Application number: 2023/90349	
What is the application for?:	Erection of detached dwelling
Address of the site or building:	adj, 11, Park View, Cleckheaton, BD19 3AN
Postcode:	BD19 3AN

Site Plan 1:100

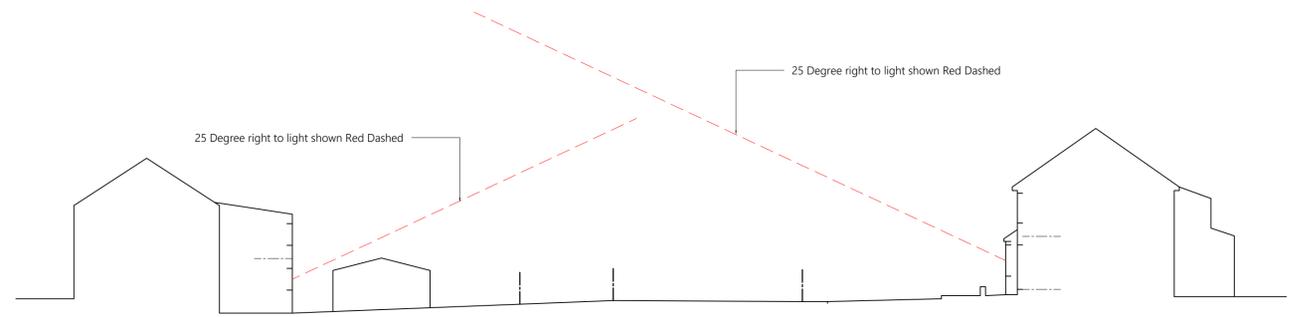
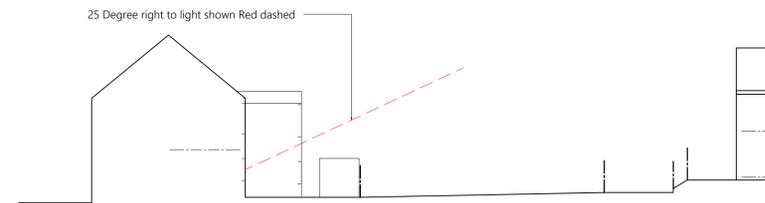
Type of comment: An objection	
Do you wish your comments to be published on the website anonymously?	Yes
I object to this application for the same reason the previous three applications were refused.Nothing has changed ,the plot is too small and parking is already a problem .
